**Demolition of Harbour Control Tower (HCT), & construction of an interpretive structure on the site of the HCT – Barangaroo Headland Park and Northern Cove Main Works, Barangaroo.**

Thank you for your letter received 30 April 2014, requesting Transport for NSW (TfNSW) to review and comment on the subject proposal. Please accept this letter as a joint Roads and Maritime Services (RMS) and TfNSW response to the subject proposal.

Figure 14: Proposed road closures (red-hatching) associated with the demolition of the HCT.

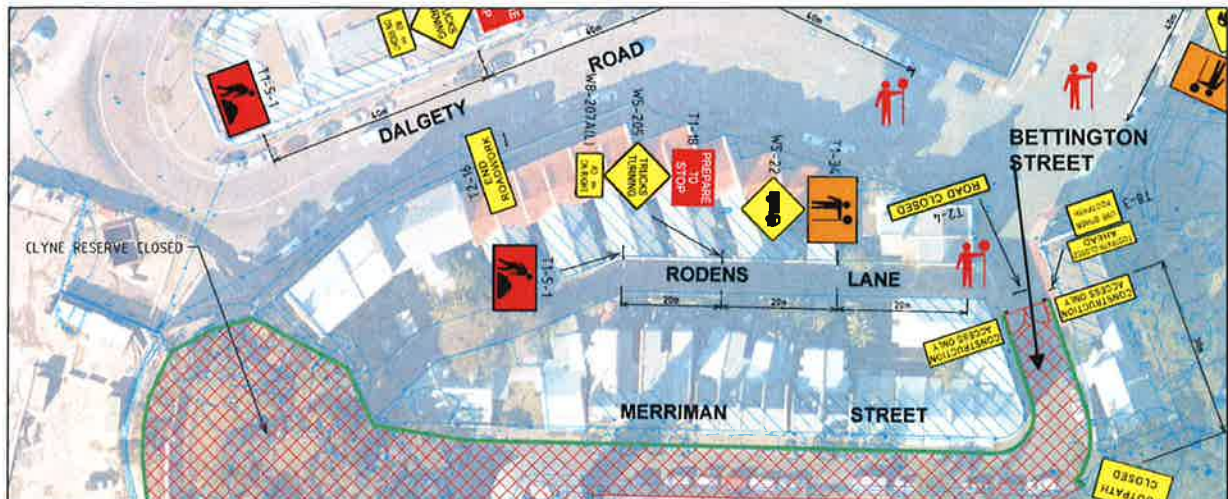
- The proposed Merriman Street closure to general traffic during demolition will require the proponent to prepare a Traffic Management Plan (TMP) which should be submitted initially to City of Sydney and for referral to the RMS for endorsement. The TMP must also examine the implementation of appropriate measures to address the temporary loss of on-street resident car parking.

DEMOLITION OF HARBOUR CONTROL TOWER
SWEPT PATH ASSESSMENT
AUSTROADS 12.5m HEAVY RIGID VEHICLE
INGRESS MOVEMENT

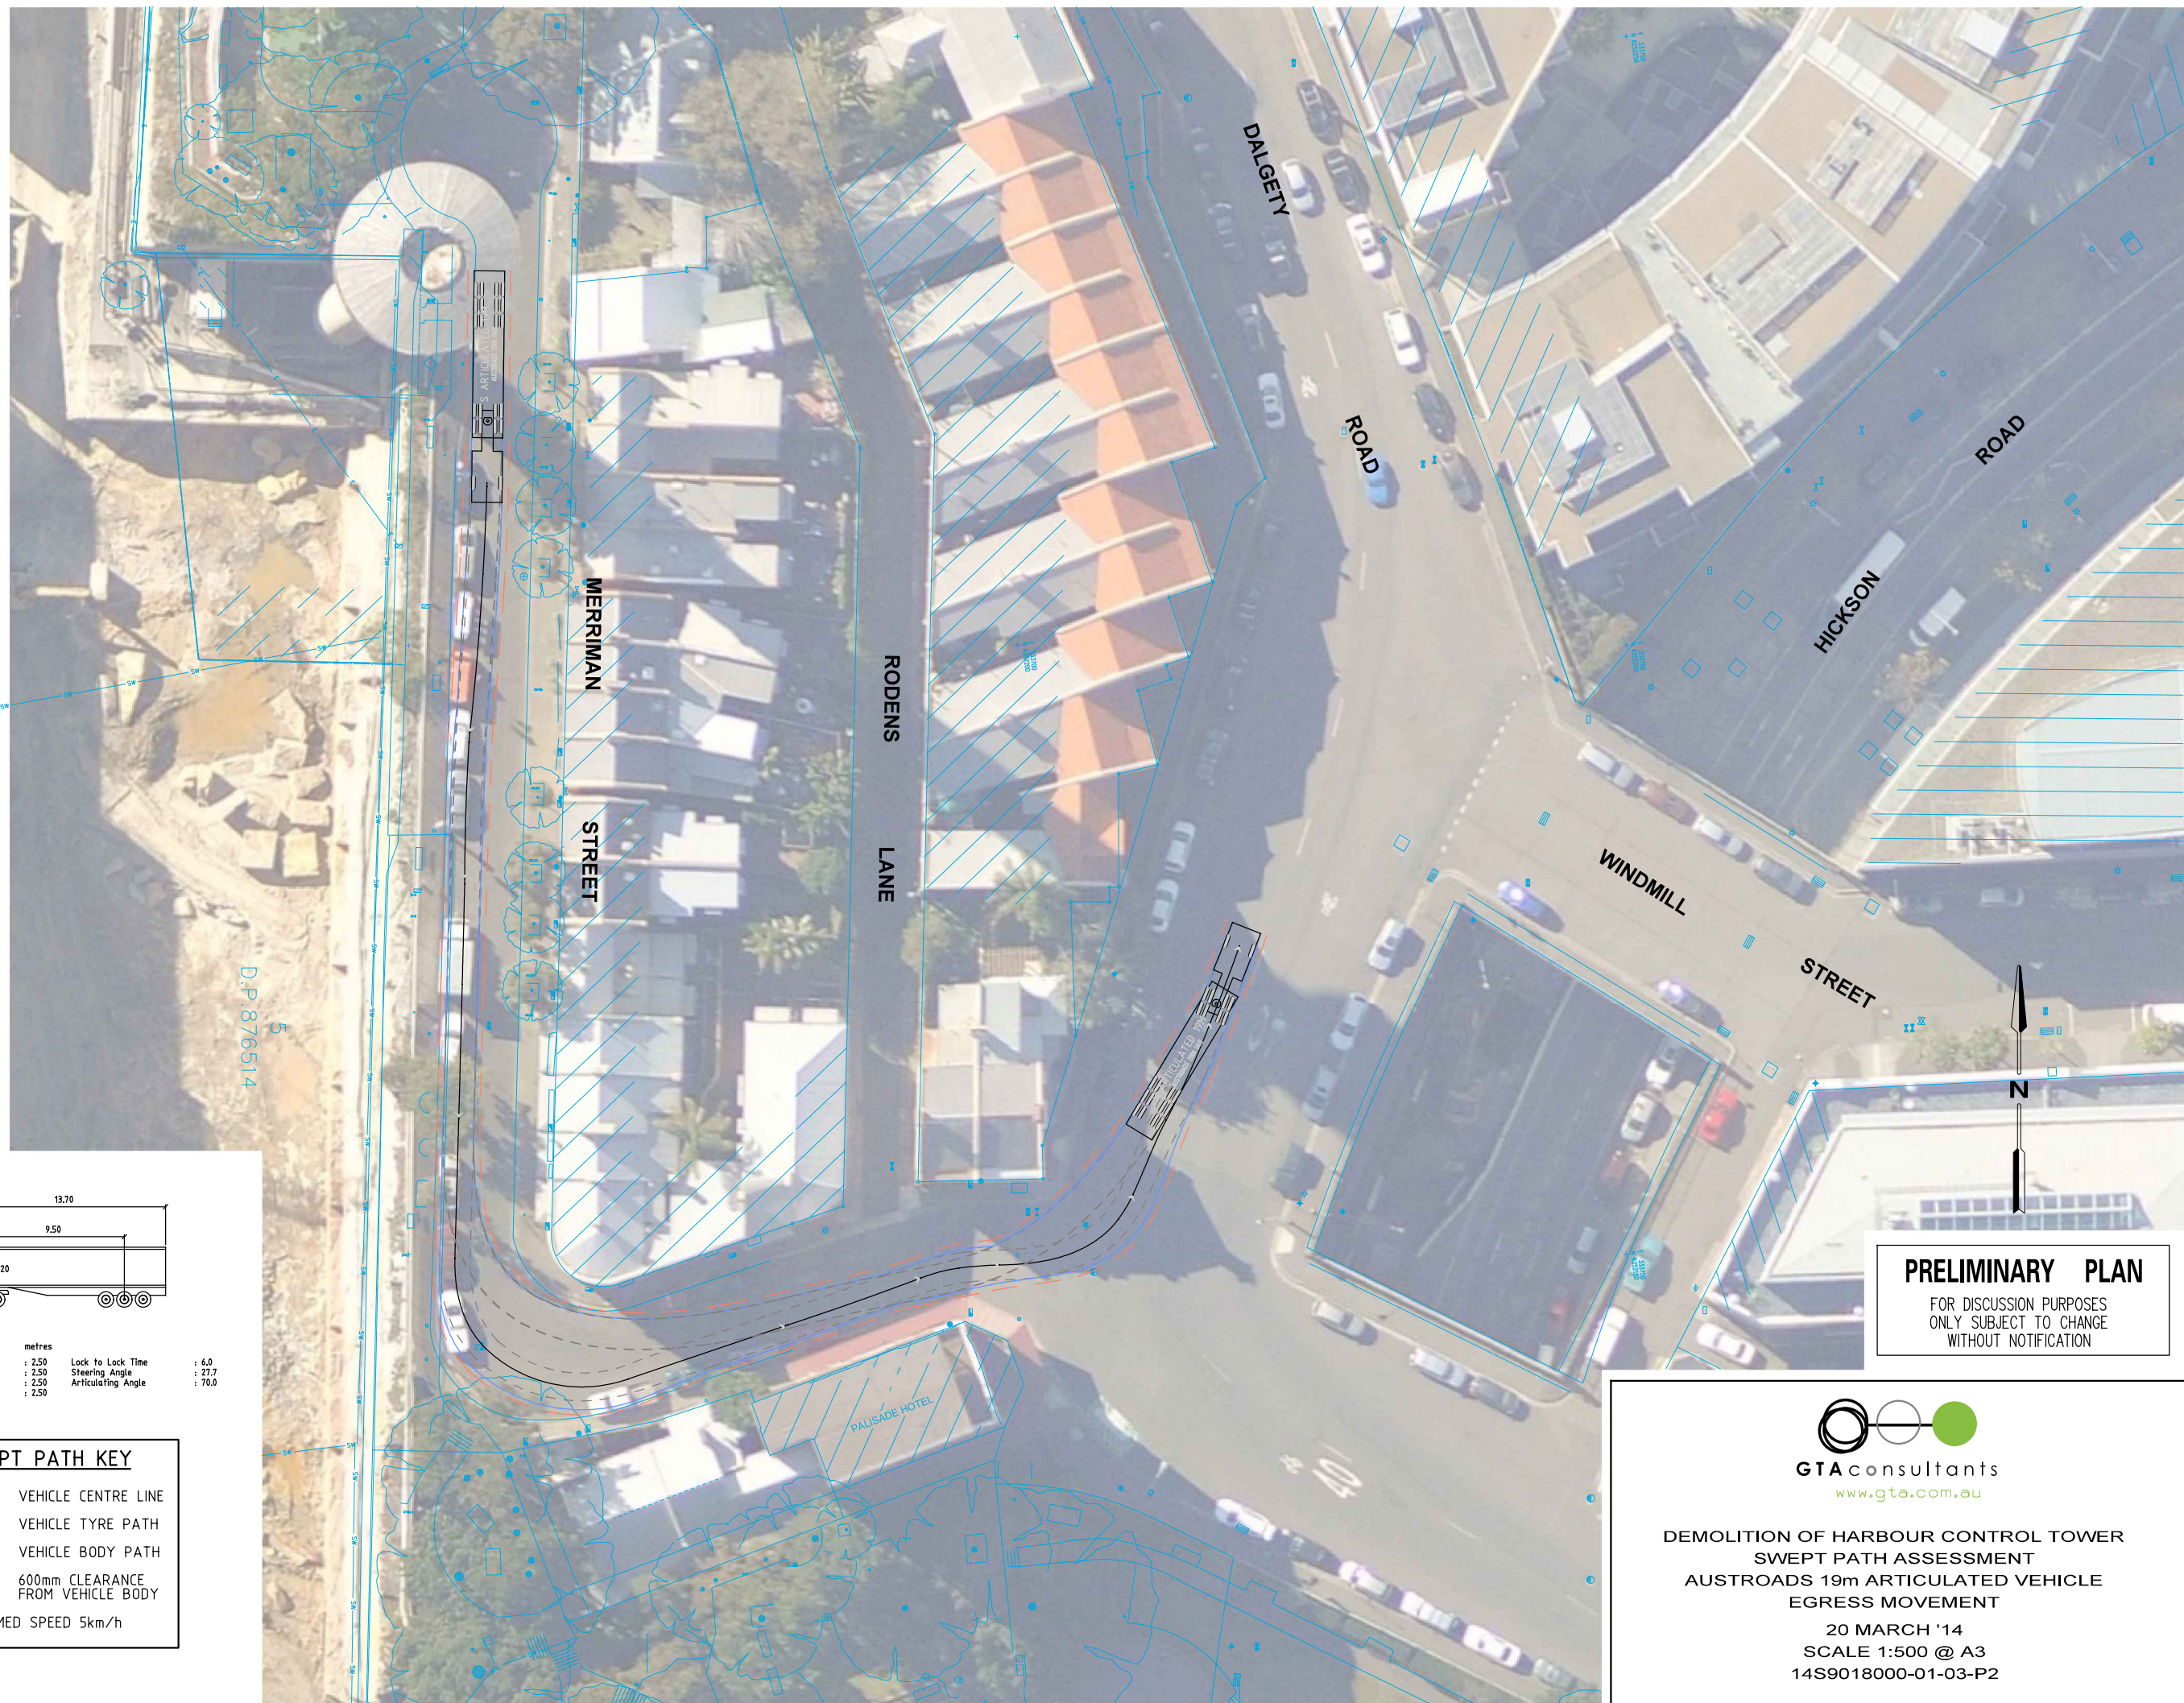
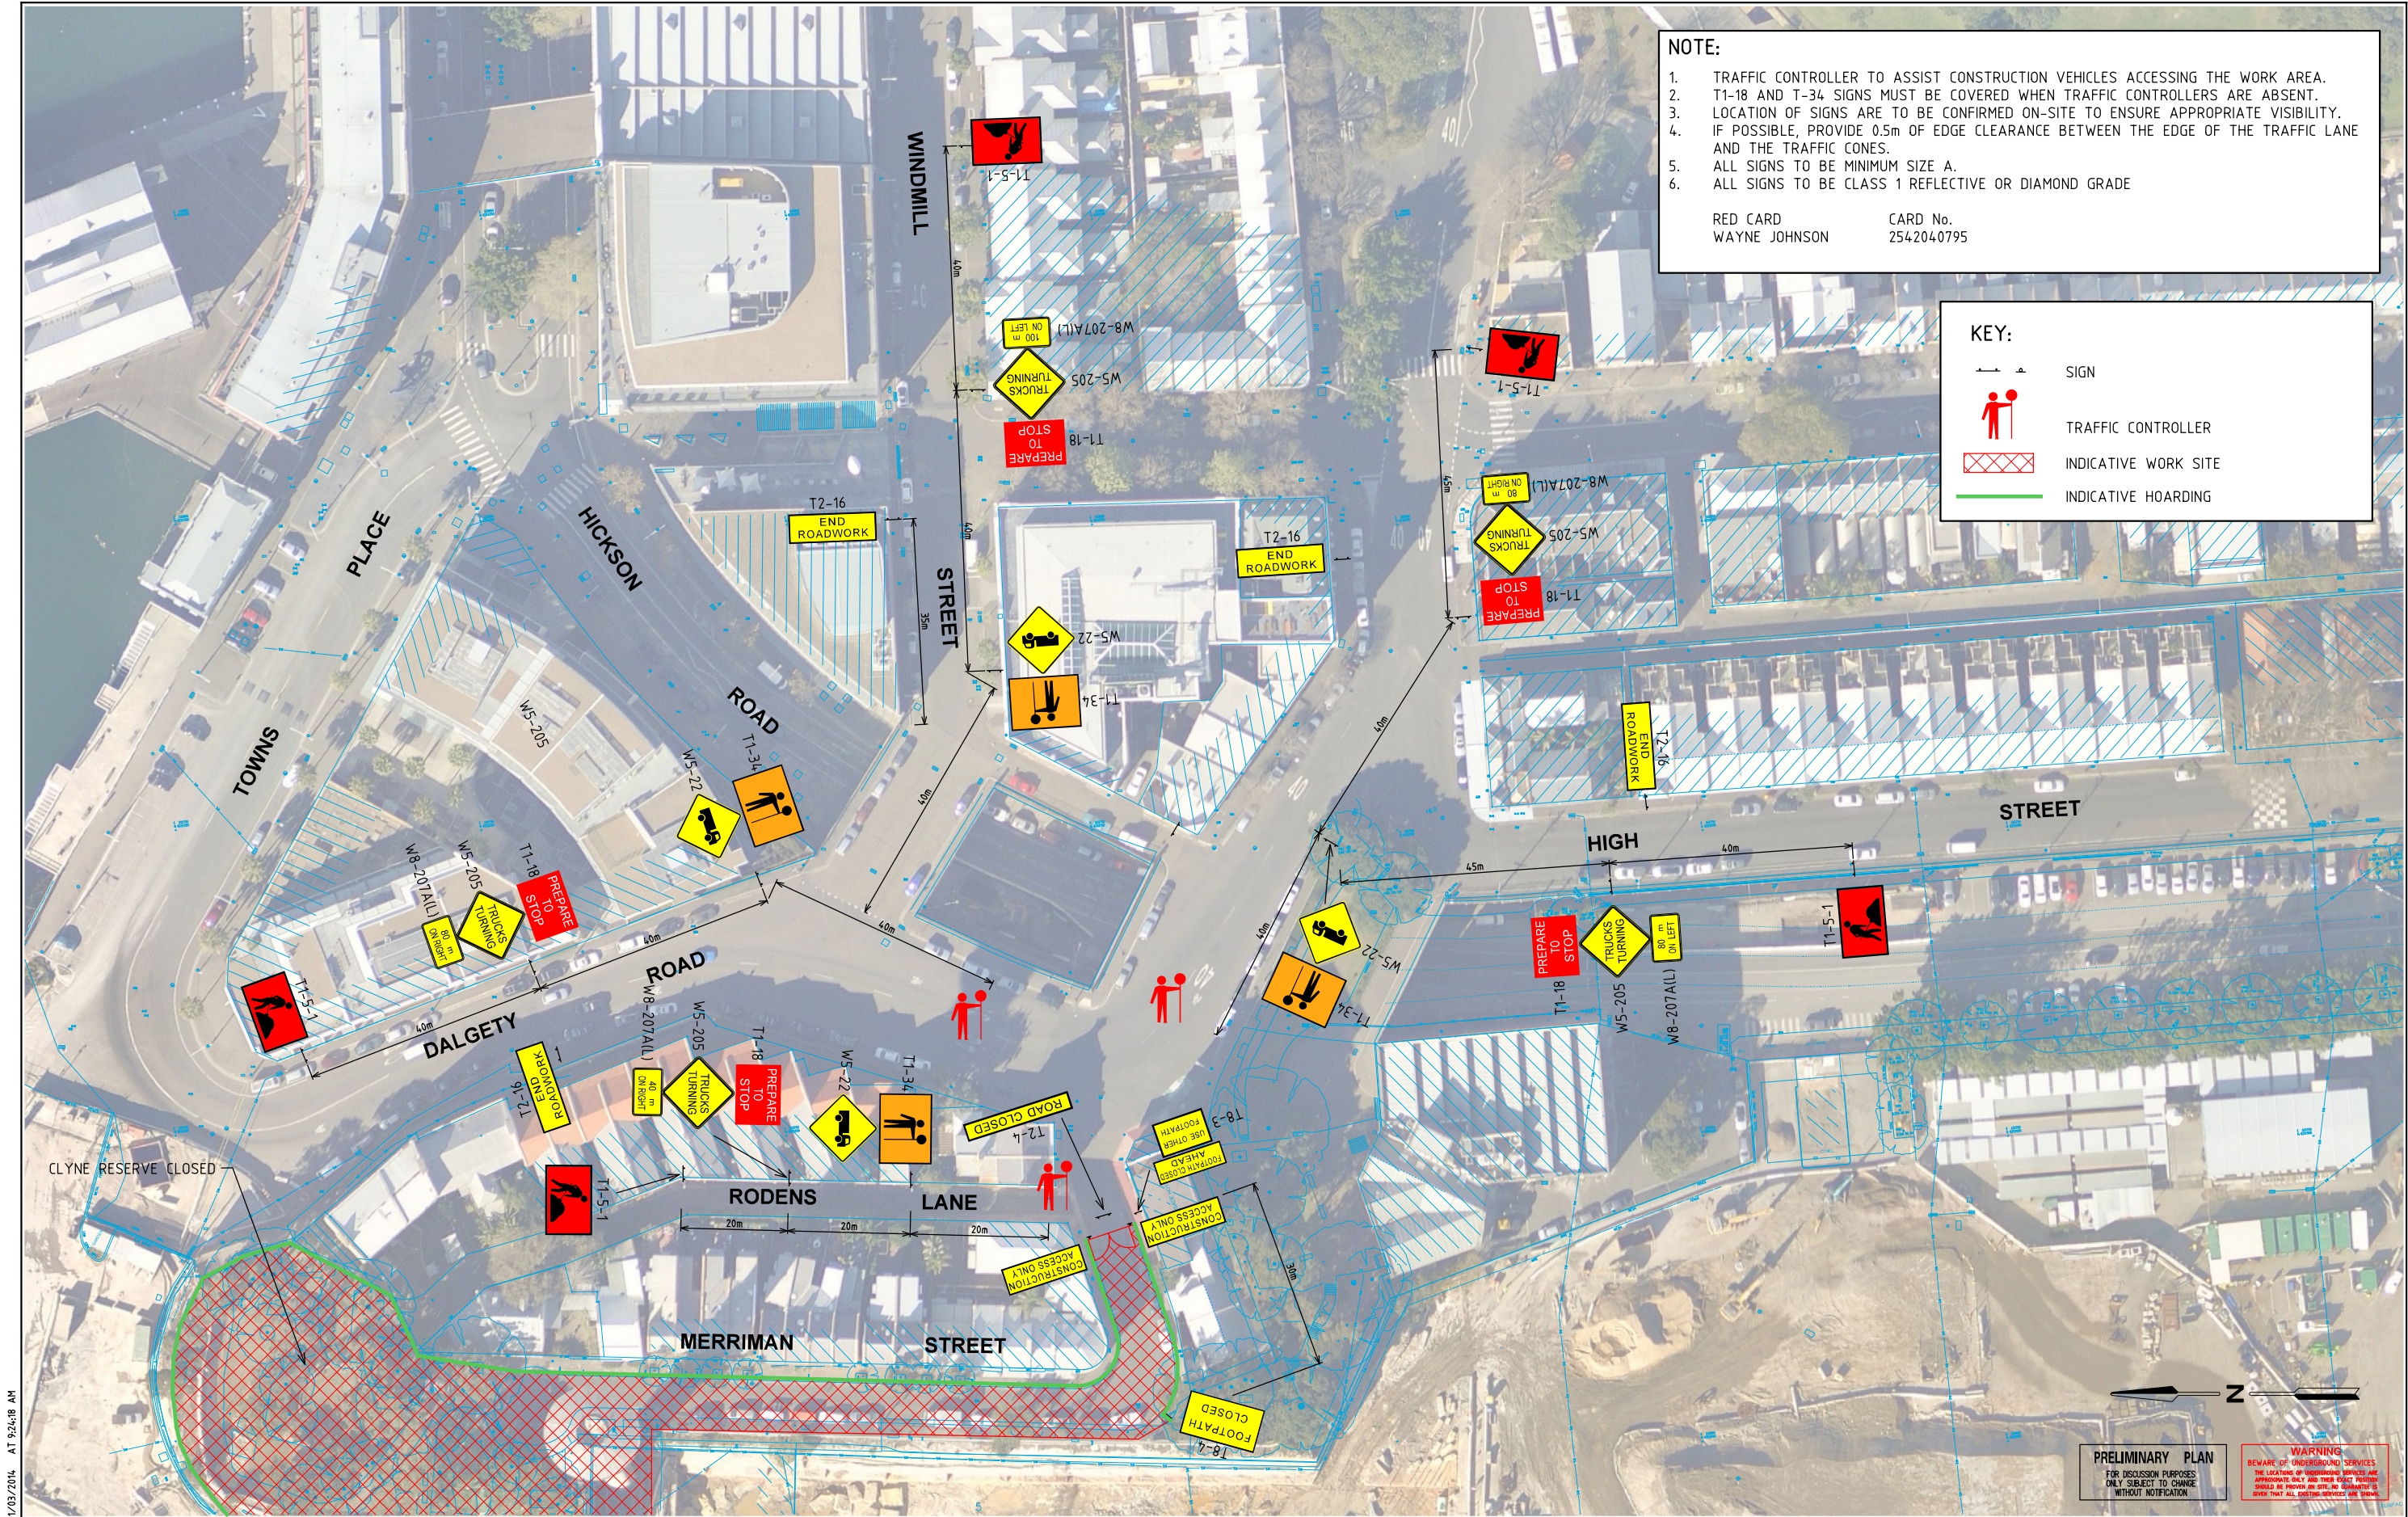
- Consultation should be undertaken with the City of Sydney regarding the proposal and is to be satisfied with the submitted Austroads Swept Path Assessment Diagrams for 19m Articulated Vehicle /12.5m Heavy Rigid Vehicle (ingress / egress movements) into and out of Merriman Street.
